**WELWYN HATFIELD BOROUGH COUNCIL  
EXECUTIVE DIRECTOR - PLANNING, PUBLIC PROTECTION AND GOVERNANCE**

**DELEGATED APPLICATION**

**Application No:** 6/2021/3051/ADV  
**Location:** 71-73 Moors Walk Welwyn Garden City AL7 2BQ  
**Proposal:** Installation of 2x internally illuminated fascia signs  
**Officer:** Ms Kirsty Shirley

**Recommendation:** Granted

TITLE
Proposed Building Signage

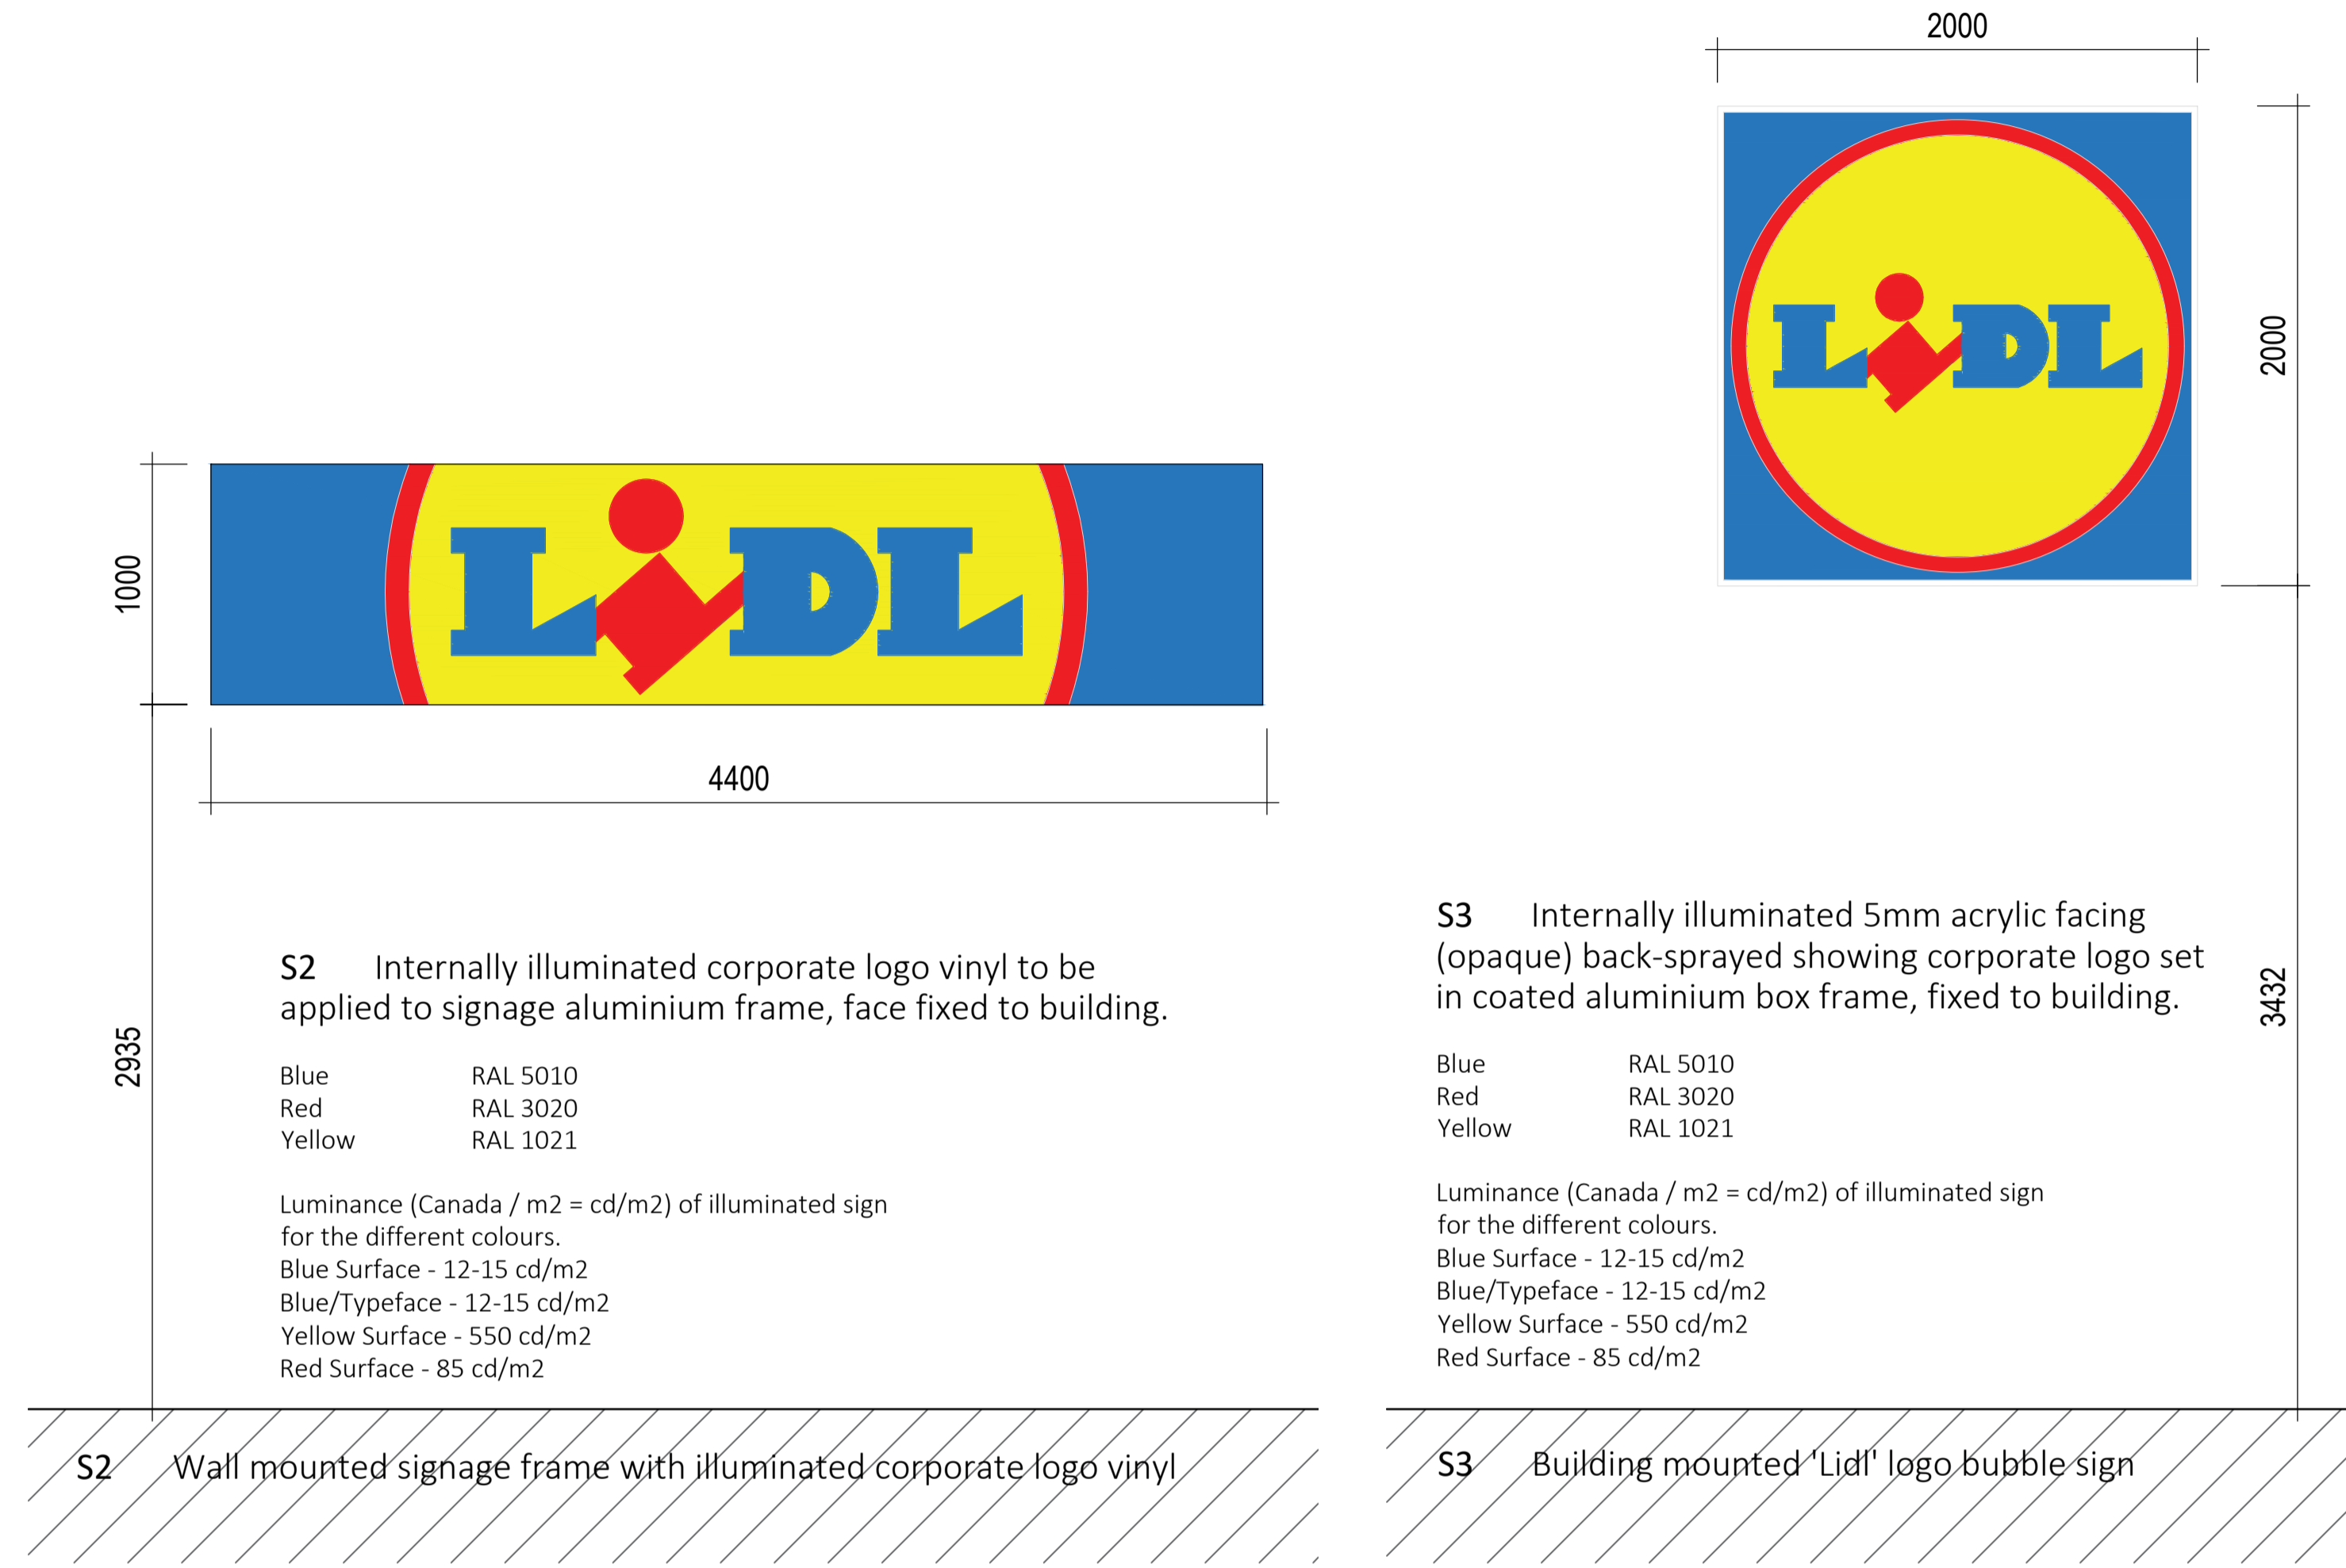
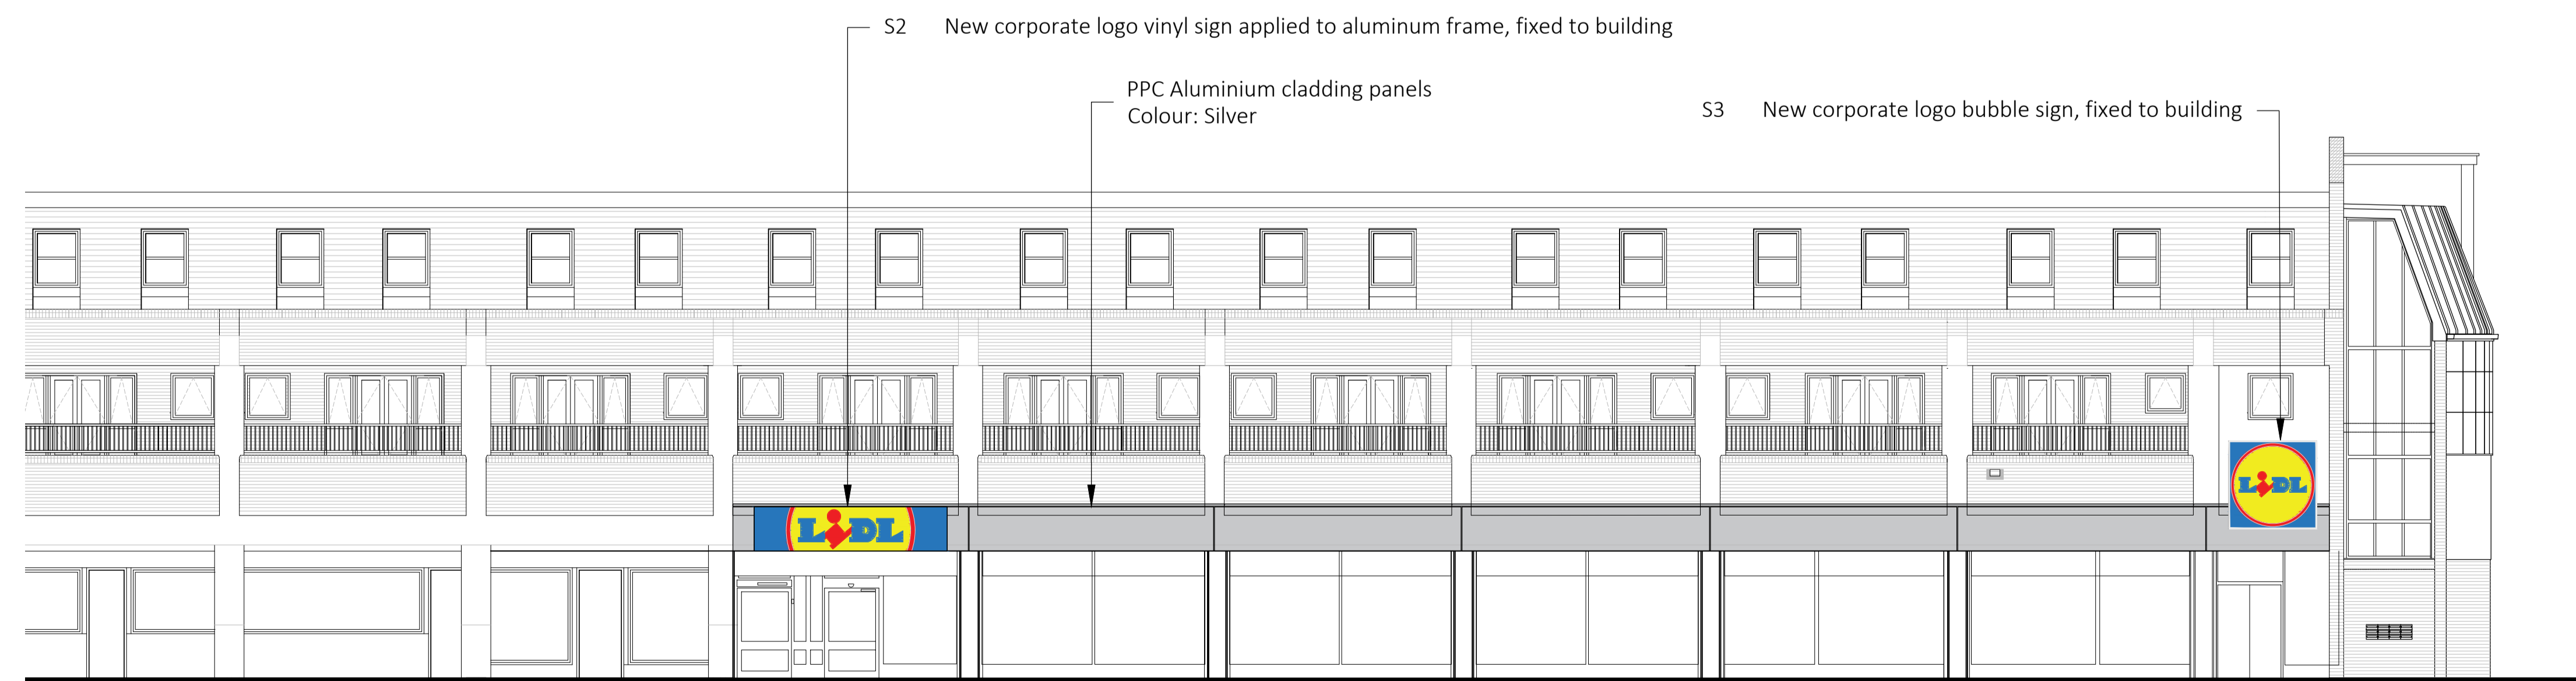
| <b>Comment (if applicable):</b> The proposed signs replace existing signs within the site and are similar in size and style to the existing signs. The proposed sign located above the store entrance will continue to be internally illuminated, but displaying a larger logo for the store. The proposed sign located to the right of the building will be internally illuminated, replacing the current non-illuminated sign. However this proposed sign will continue to display the store logo and will be the same size, shape and style as the current sign. The proposed signs would not appear out of context within the Moors Walk shopping parade which is comprised of retail and commercial units, and would not have an adverse impact on the character of amenity of the site over and above the existing situation. |   |           |          |
